## KITTITAS COUNTY COMMUNITY DEVELOPMENT SERVICES

### **Subject: Swauk Valley Ranch (LPF-18-00003) Final Plat. – Staff Review and Request for Additional Information**

**SHEET 2 OF 3**

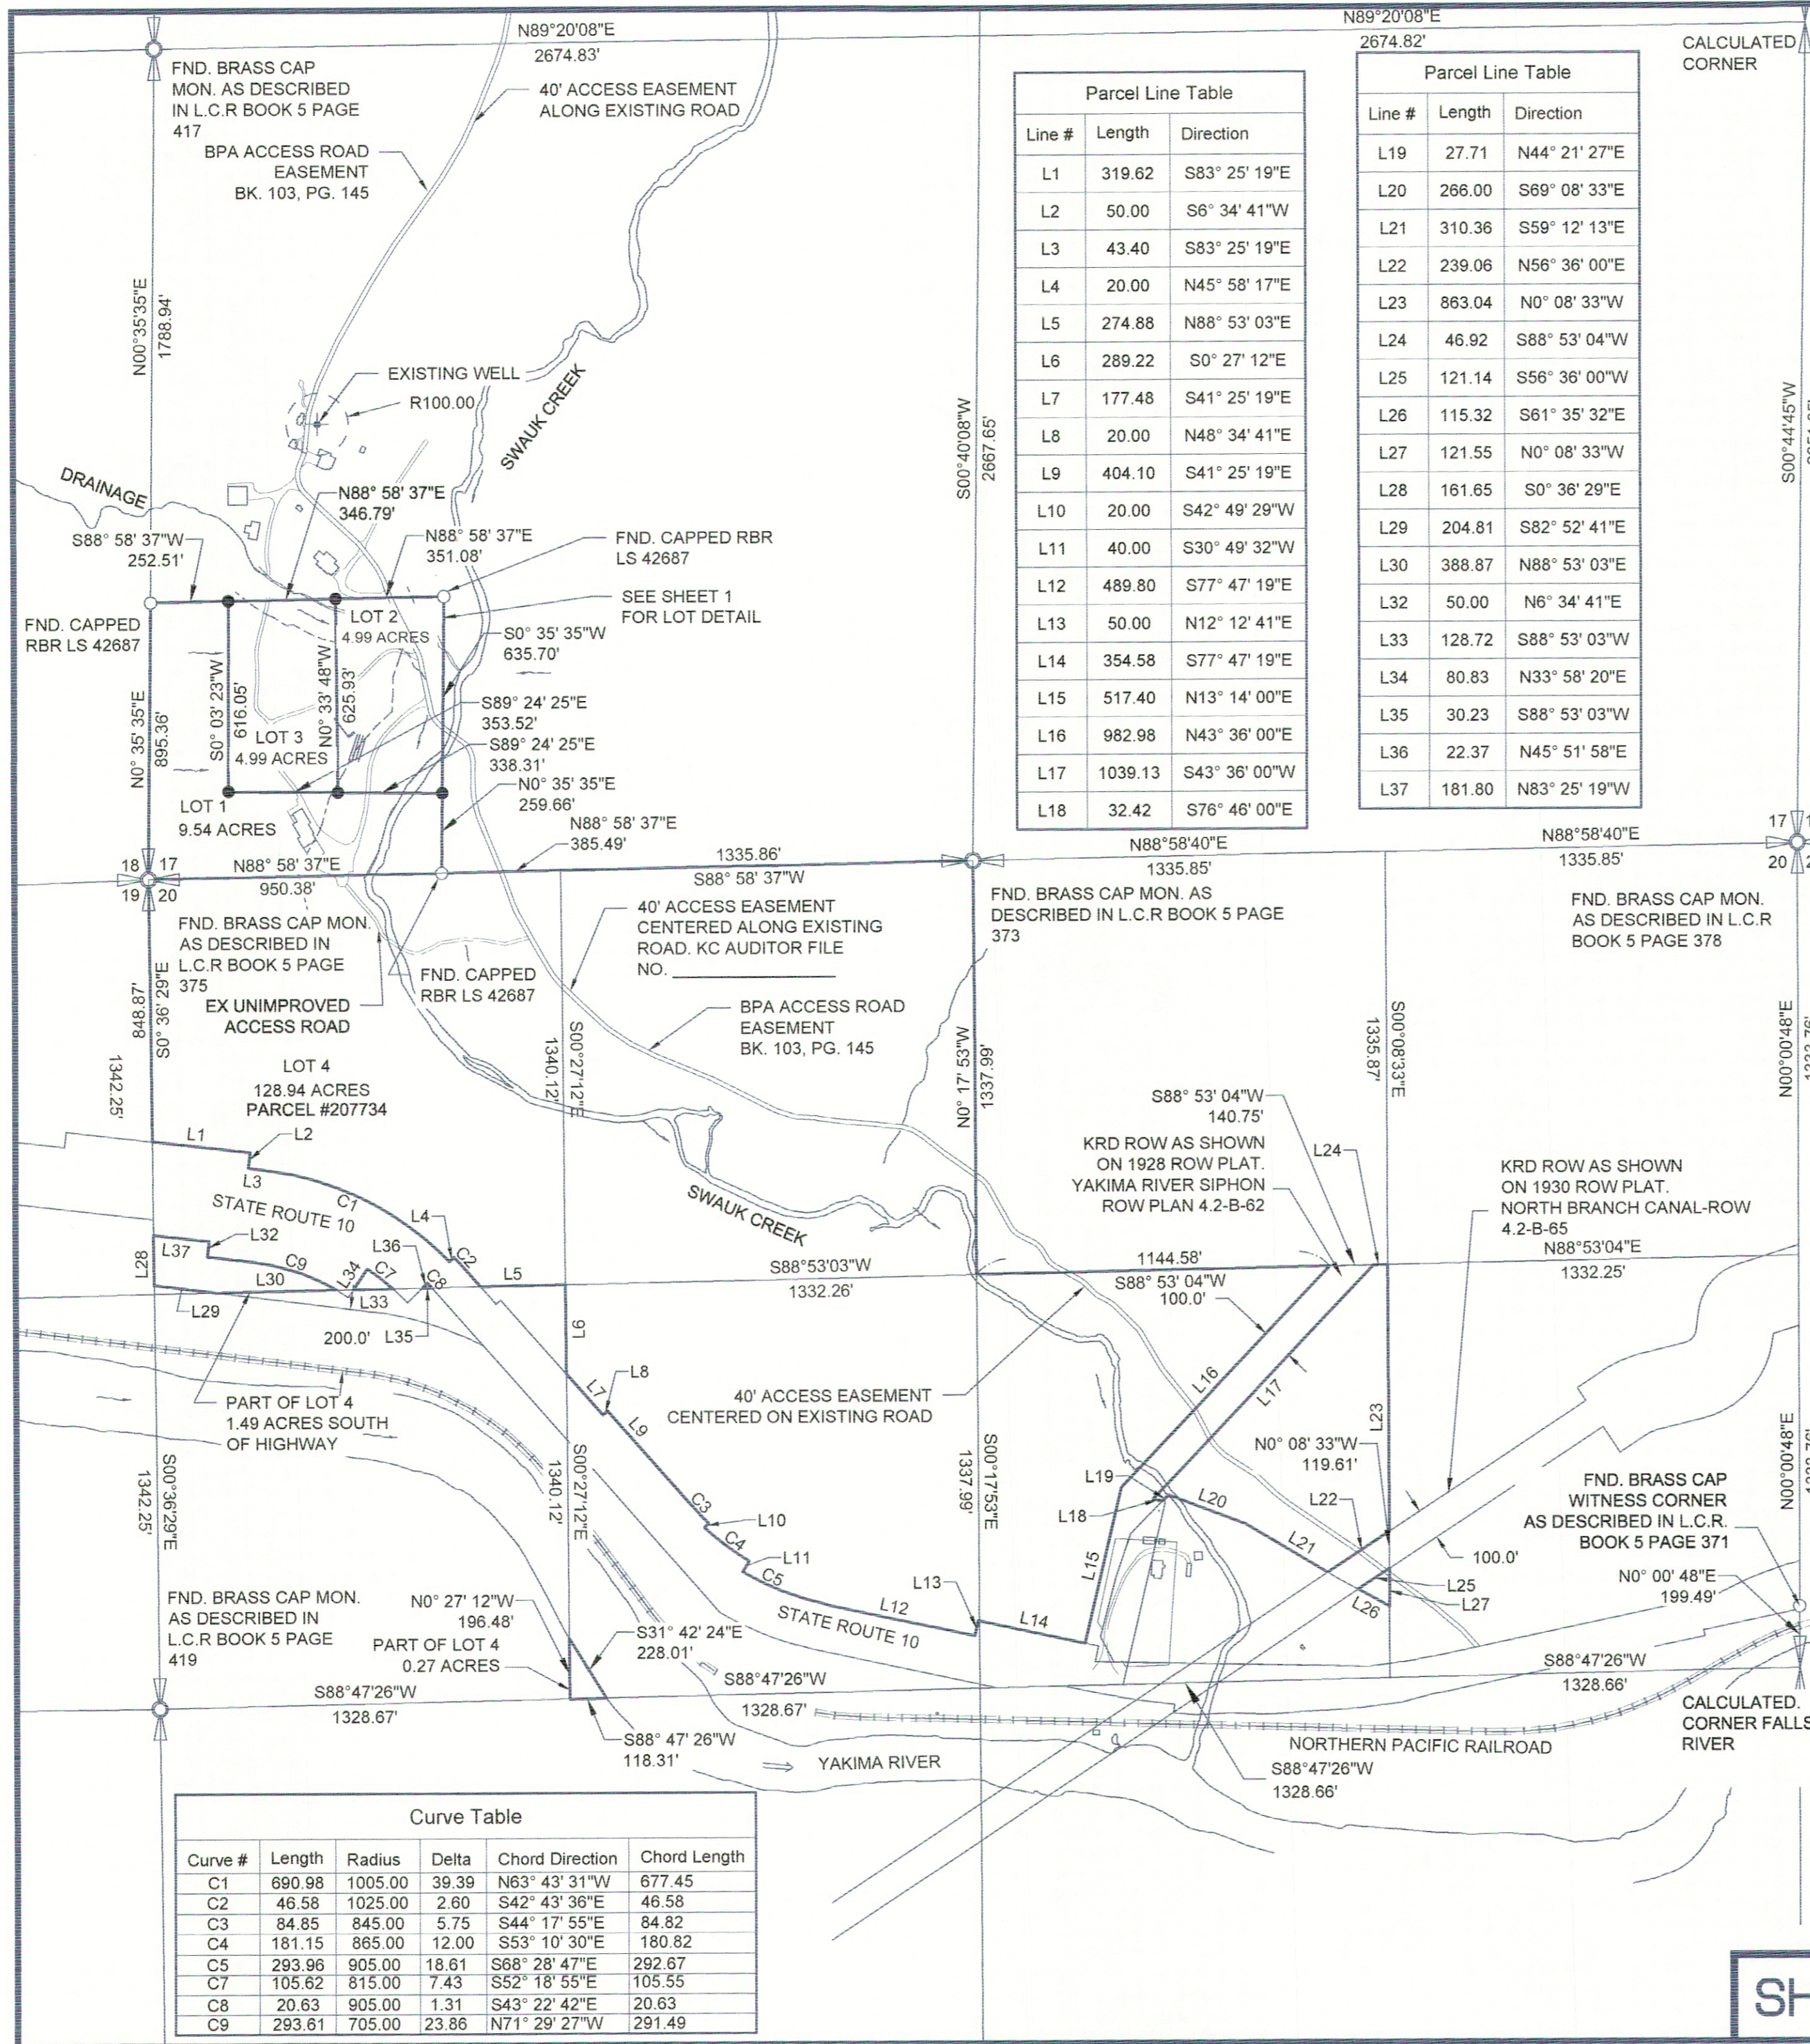
- 14) The leader arrow to the Witness corner at E1/4 of Sec 20 does not point to the witness corner.
- 15) There appears to be usage across Parcel 4 by the adjacent parcel to the East, near line 16. Usage lines shall be identified. This same parcel appears to be outlined and overlaps onto Lot 4 or the KRD r/w. This should be identified.
- 16) The closure reports do not match the radii as shown on the curve table.
